Re: Consultant Advice Note (CAN) – Baler and Wrapper Structure
Project: Frank Street, Wetherill Park

This Consultant Advice Note (CAN) has been produced to outline the fire safety issues with respect to Olsson Fire's Fire Engineering Report S15332 dated 05/10/2017 and fire sprinkler system requirements for the proposed Baler and Wrapper Structure.

DRAWING TITLE
SITE PLAN
DRAWING NO
SK1101

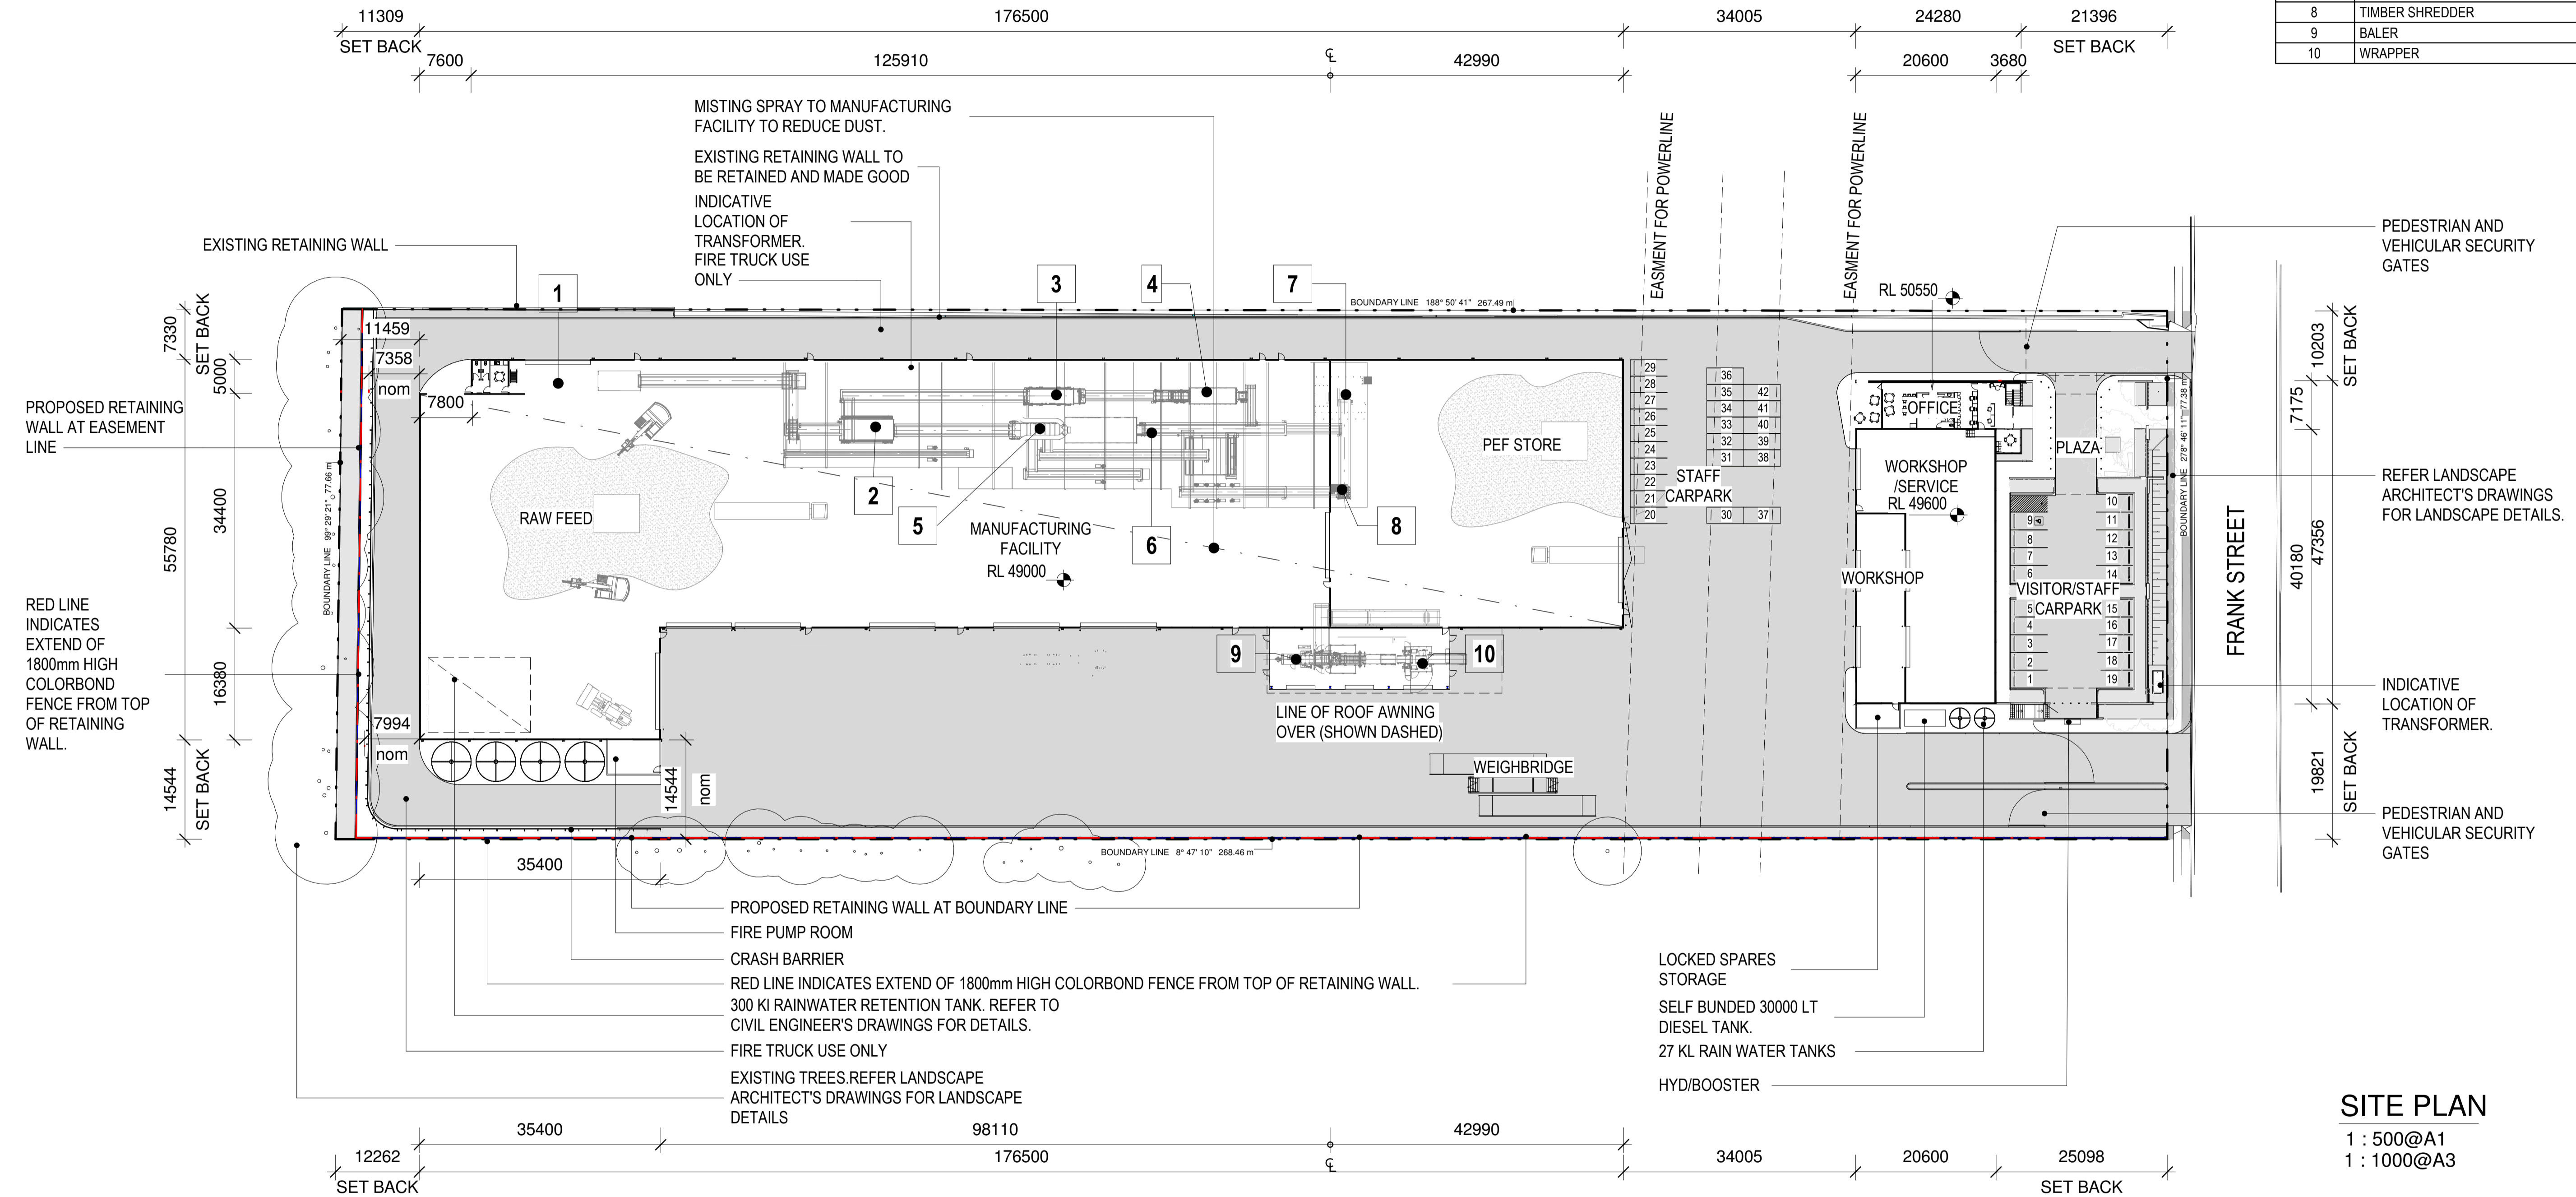
OFR can confirm that the proposed structure has no overall impact on the Fire Engineering Report S15332 dated 05/10/2017. In relation to the requirements of the fire sprinkler system. The awning has been documented as requiring sprinklers, these will provide coverage at high level. Sprinkler protection will be required underneath equipment such as conveyors or the like. Hydrant and Hose reel coverage must be provided.
